PINS Doc 1195 – NG Doc 8.20 Applicant’s Post Hearing Submissions:

PINS Doc 1208 – NG Doc 8.21 Applicant’s Responses to Other Parties’ Deadline 5 Submissions:

Arcady Assessment
Site Access Junction
Scale 1:1000@A3

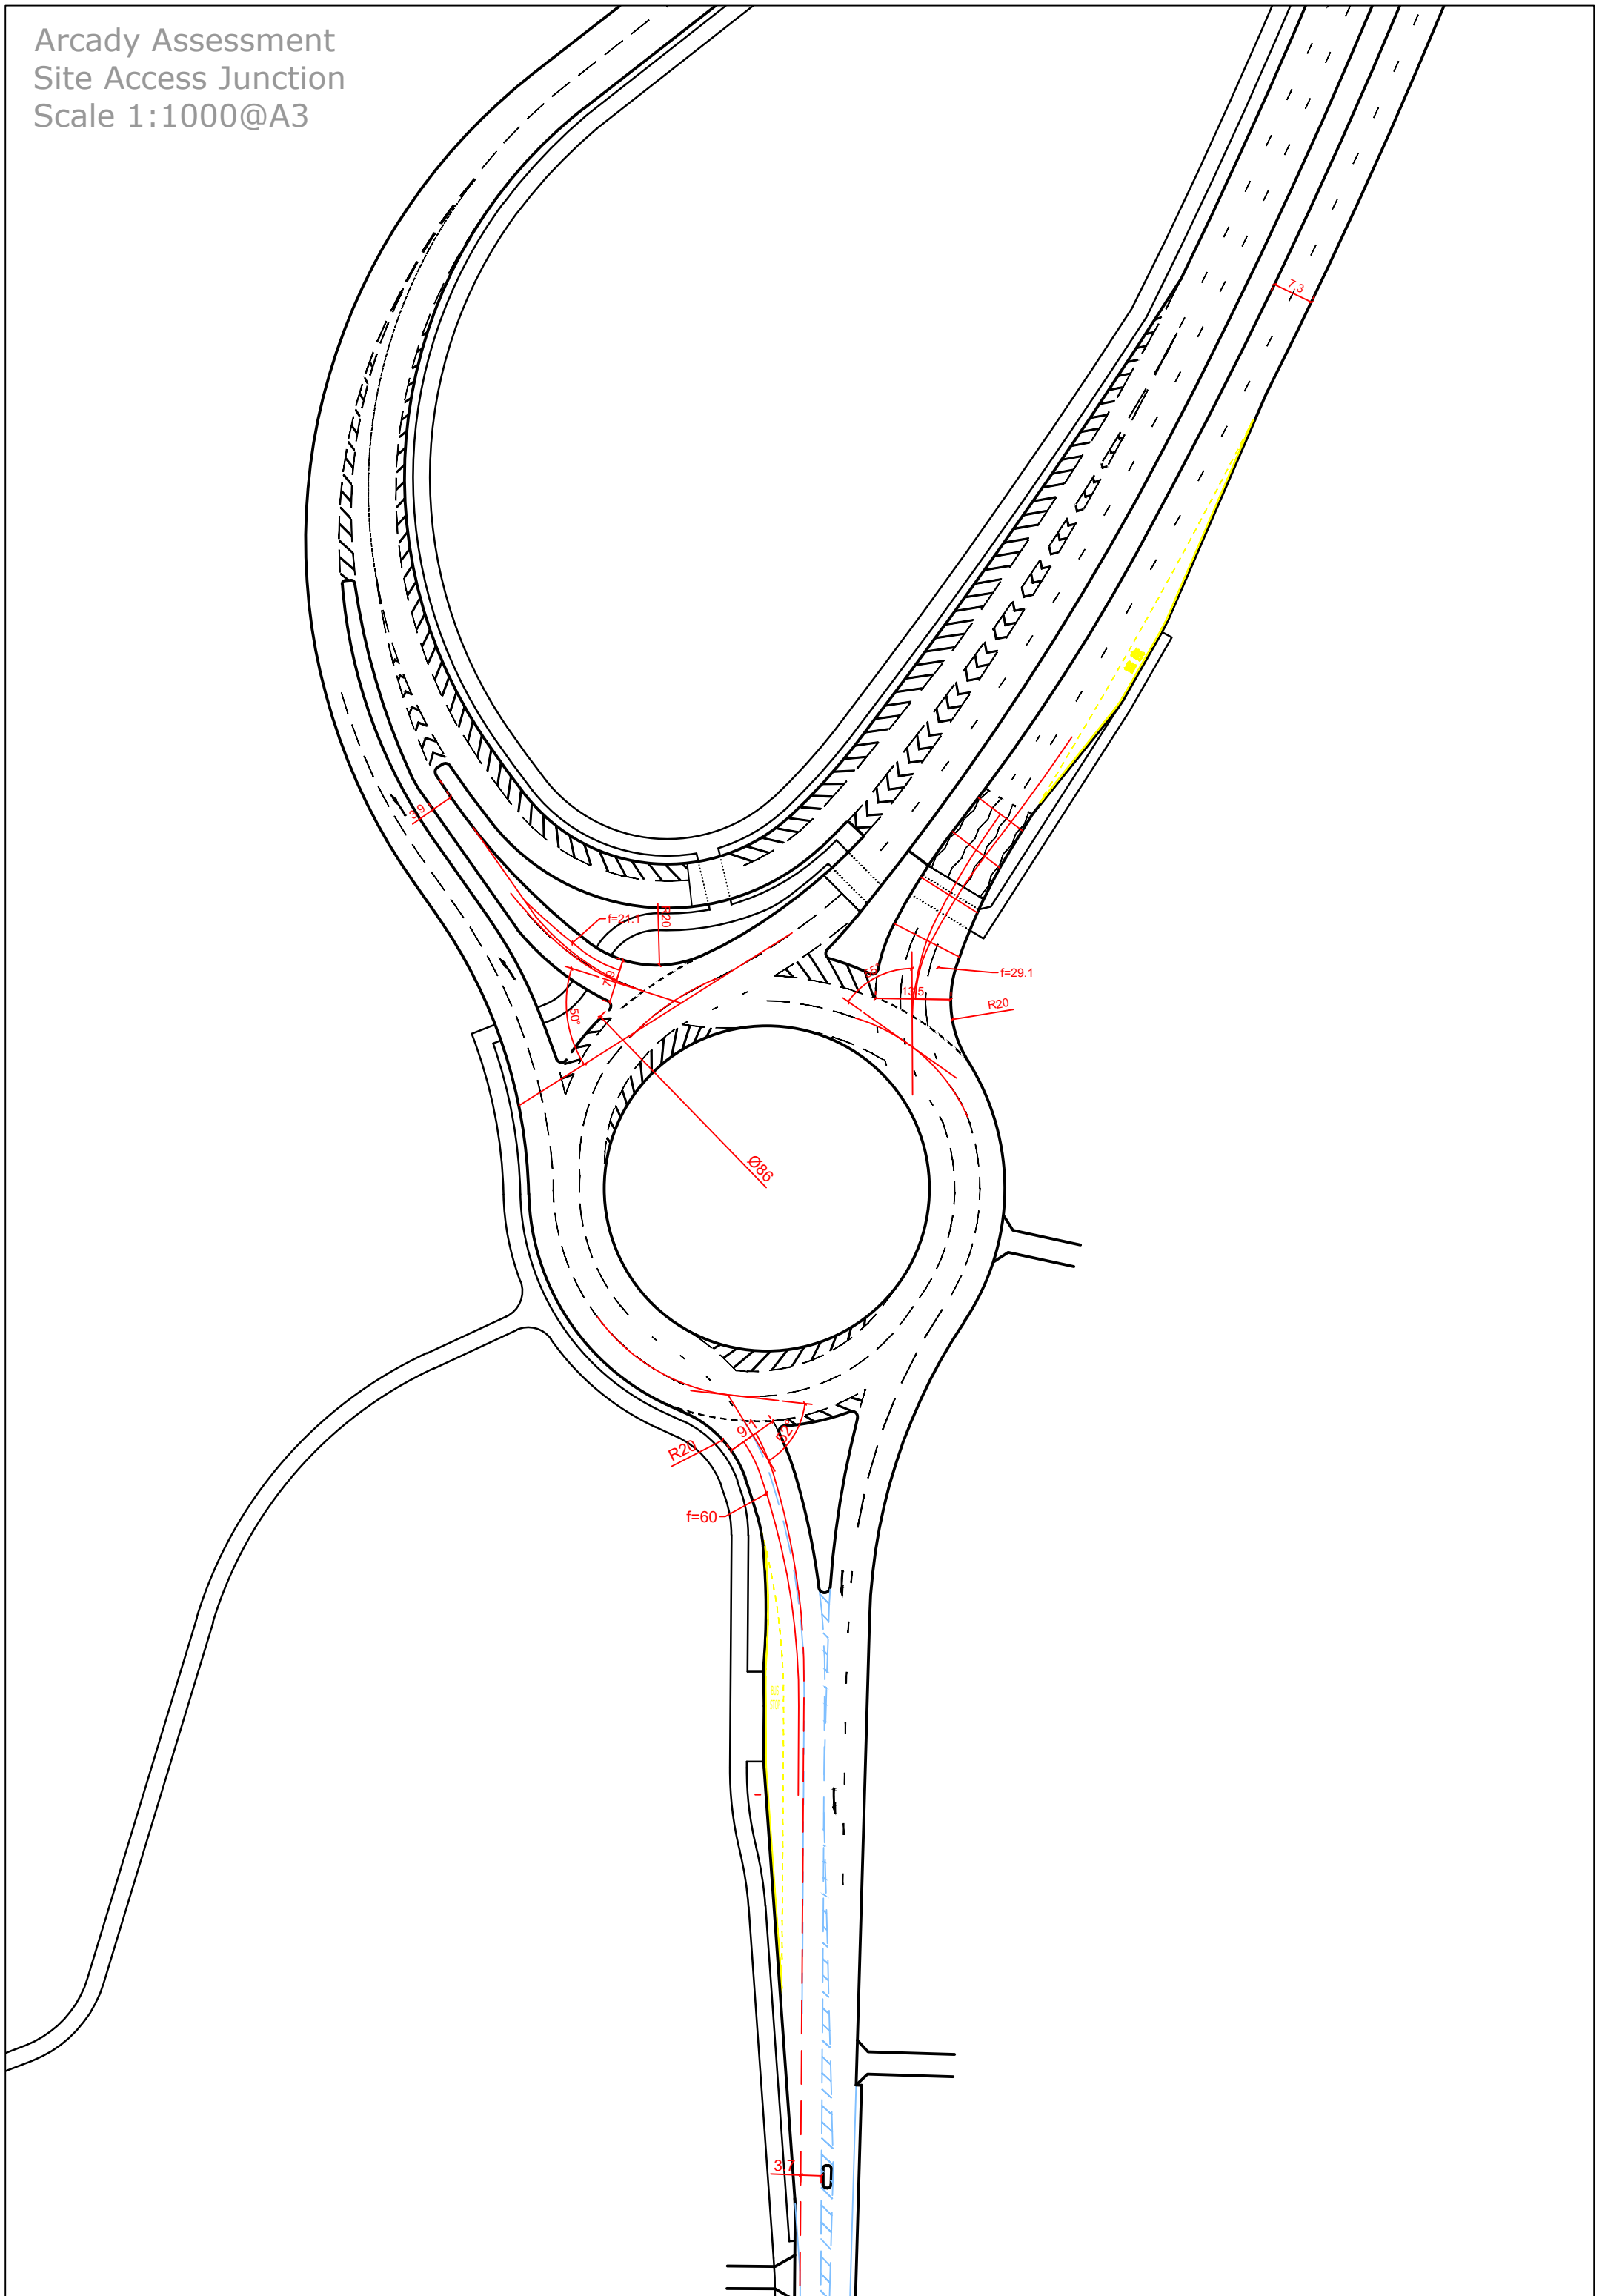
1. Although 3 physical lanes do not enter the site together, there would still be traffic entering from 3 lanes merging. Two originate from J15 and one from the A508 south. So, two lanes would have to merge into one lane twice within approximately 100 metres with the consequent potential for accidents. At peak hours there are predicted to be 838 vehicles, including 138 HGVs entering the site, or 1 every 4.3 seconds. The mixture of vehicle types and so many HGVs is a potentially dangerous mix. Please refer to our WR Pt B, Ch 3 for further details.

2. Fig 2 of ES TR App 12.1 – TA 27 (PINS doc 446) referred to, showing the first 260m of the site entrance road, **omits the first warehouse entrance on the left and stops short of the internal roundabout with a second warehouse entrance leading off it, also to the left**, all of which is prior to traffic entering the main site. The conclusion can only be that the impact of vehicles disrupting the smooth flow of traffic to negotiate these three impediments have not been included in the traffic modelling. This is a **serious flaw** as traffic will have been assumed to flow *ad infinitum* with no hold ups. In practice there will be, and this will slow traffic sufficiently to cause a ripple effect back to the A508 and potentially to J15. The Applicant has produced no evidence to the contrary.

3. As stated previously, in view of the above it would be unsafe to change the internal layout so close to the site entrance without re-modelling ALL the revised layouts and roadways **in conjunction with** re-modelling of the A508 and J15 traffic. To depend on approval of the detailed layout of the internal road network following granting a DCO, as suggested, would be too late, especially if it is carried out in a ‘bubble’ as the site access has been.

4. **This is the most serious flaw in the Applicant’s traffic modelling and potentially invalidates most of the so-called mitigation proposals.**
